**Cessna Drive
Variance of Use
Letter of Intent**

October 29, 2024

it appears previous staff, no longer with County, didn't upload all staff comments from review 1; we apologize. Please address comments.

8242-8244 CESSNA DRIVE VARIANCE OF USE SITE PLAN

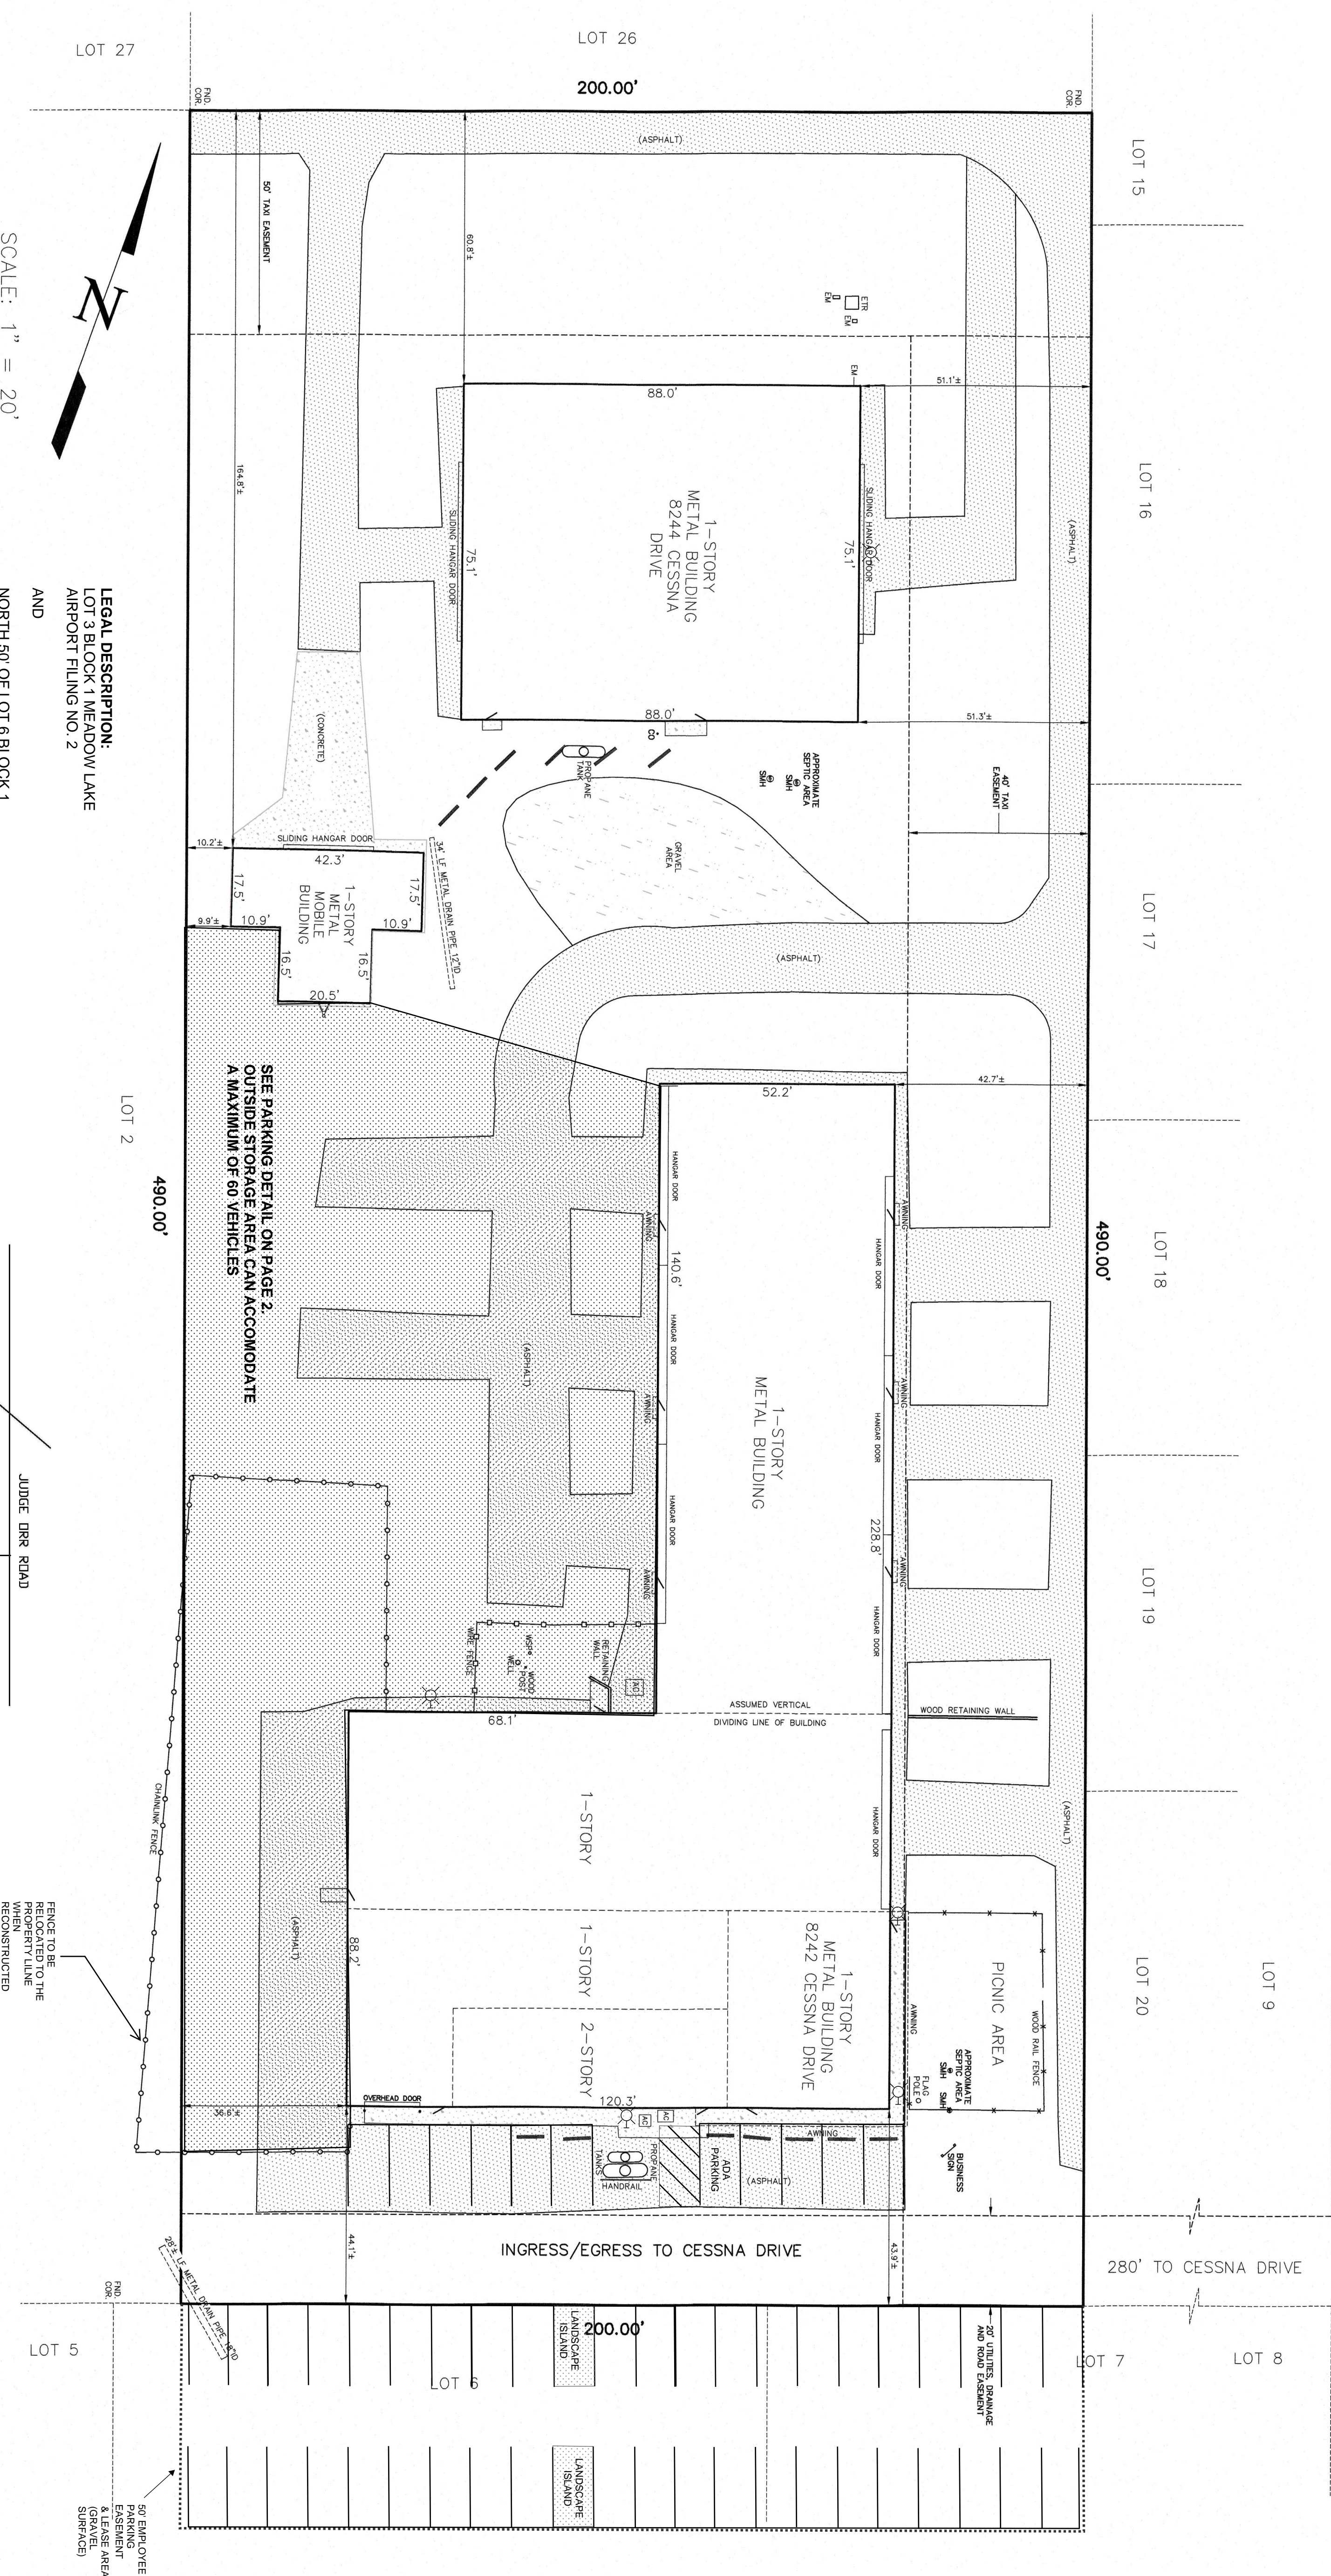
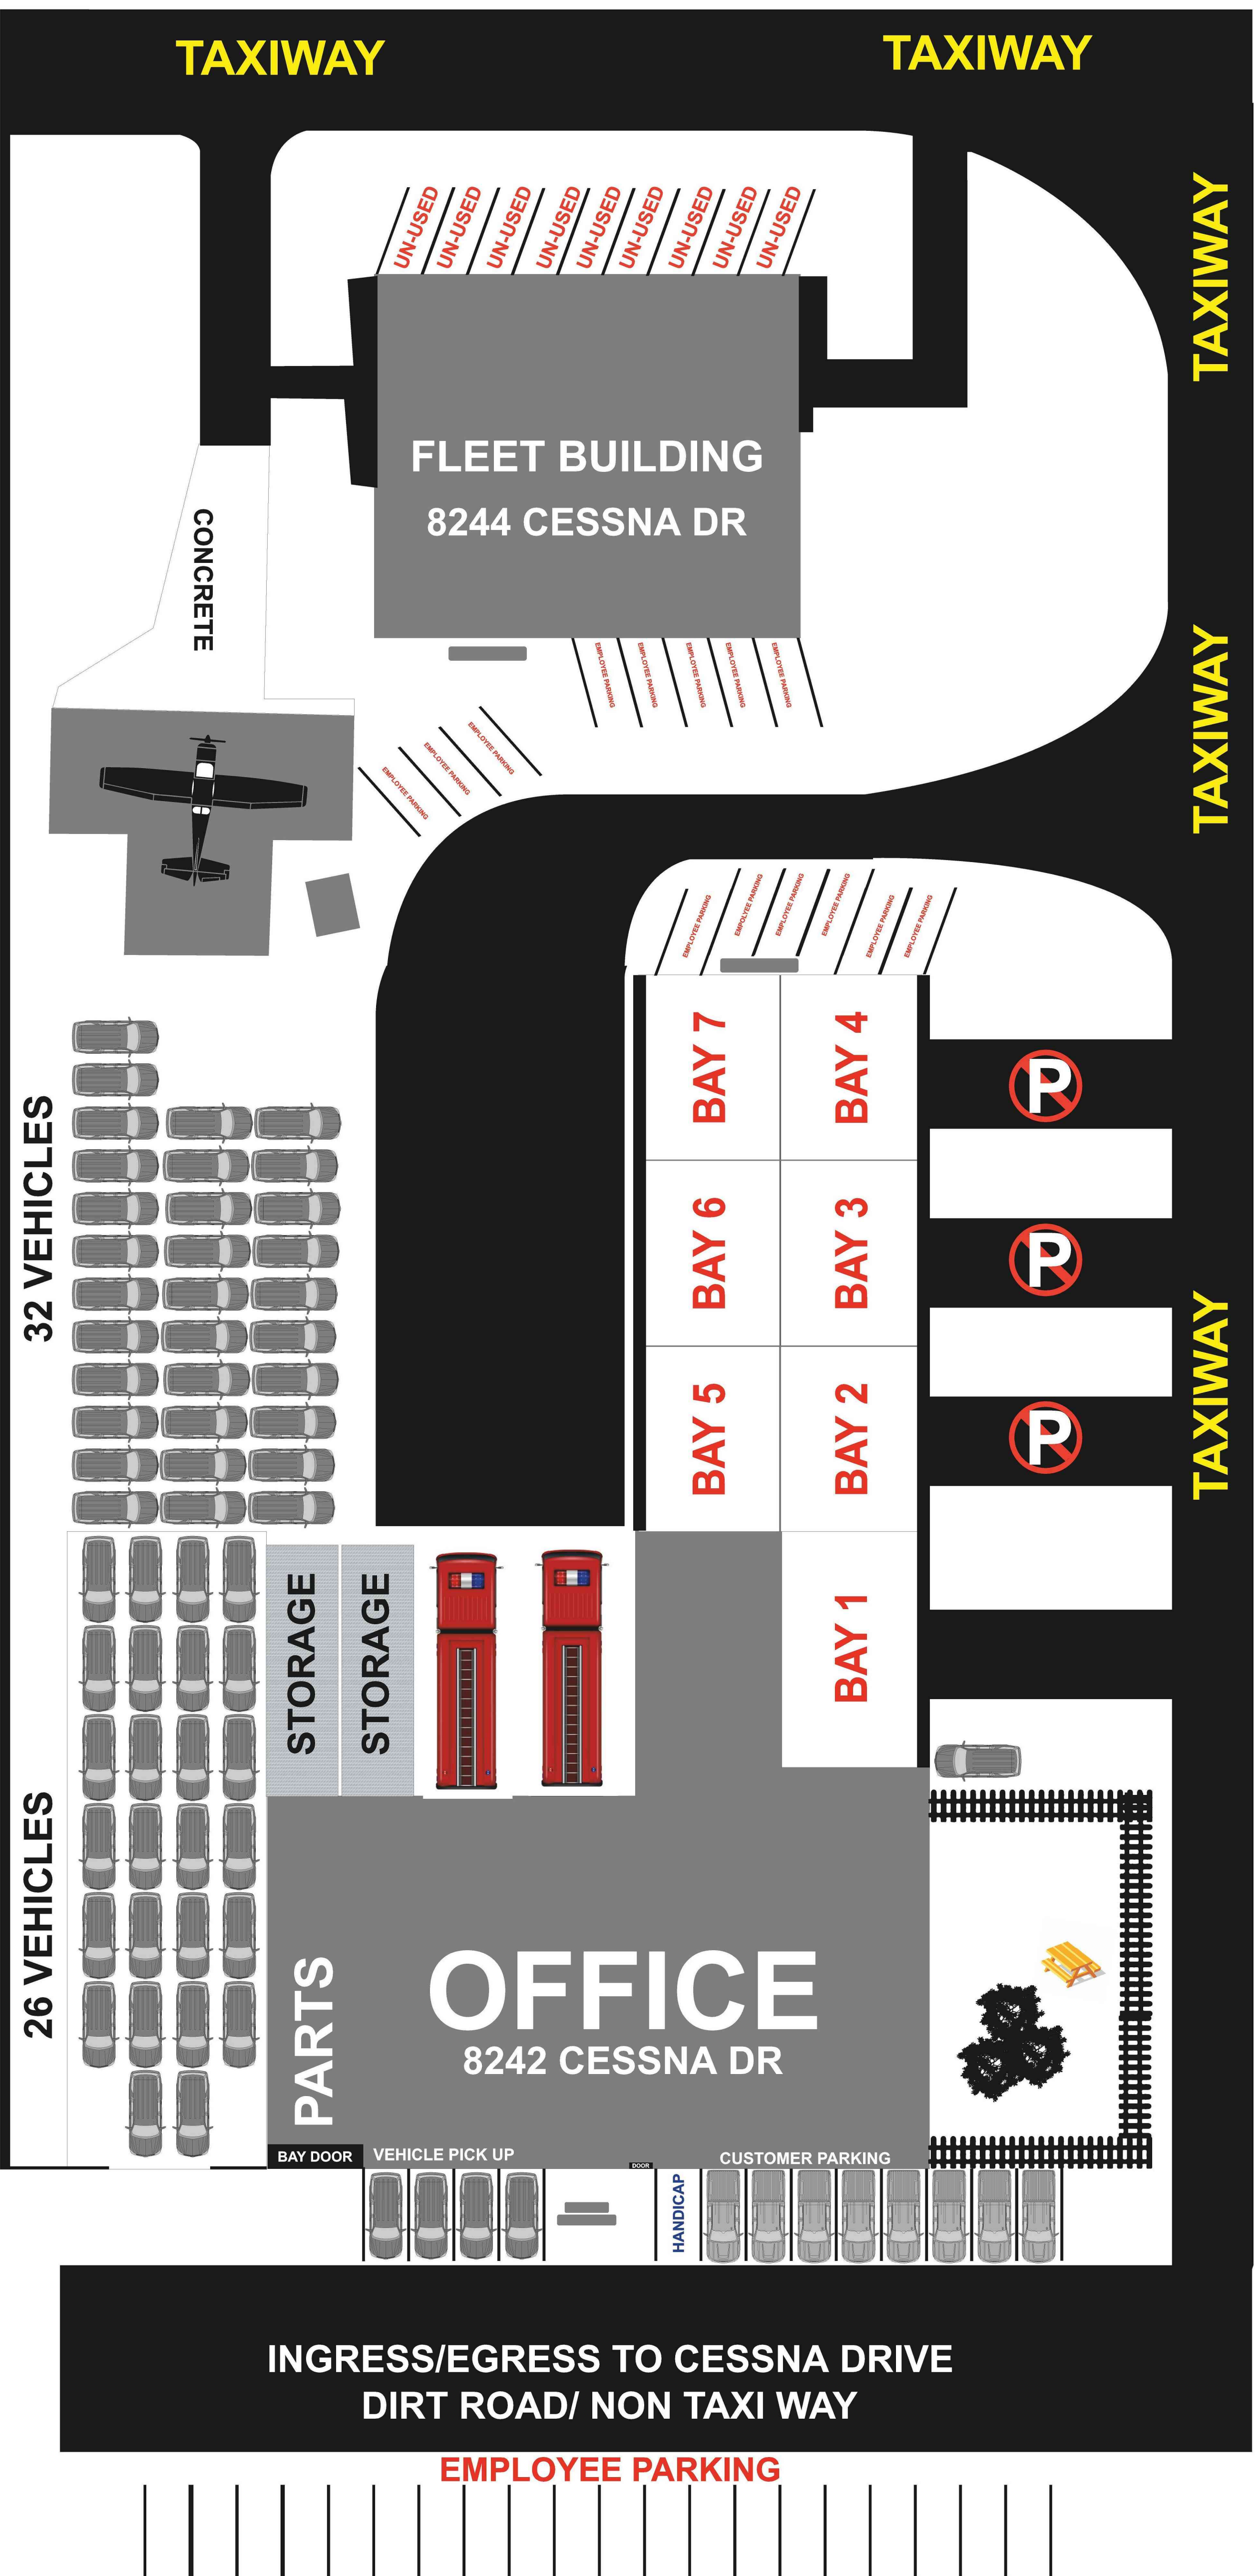
add other parcel that the cars park on for the employees that work for the garage repair shall be included in variance

plus parking area

use is for upto 60 of governmental customers vehicles only please in request
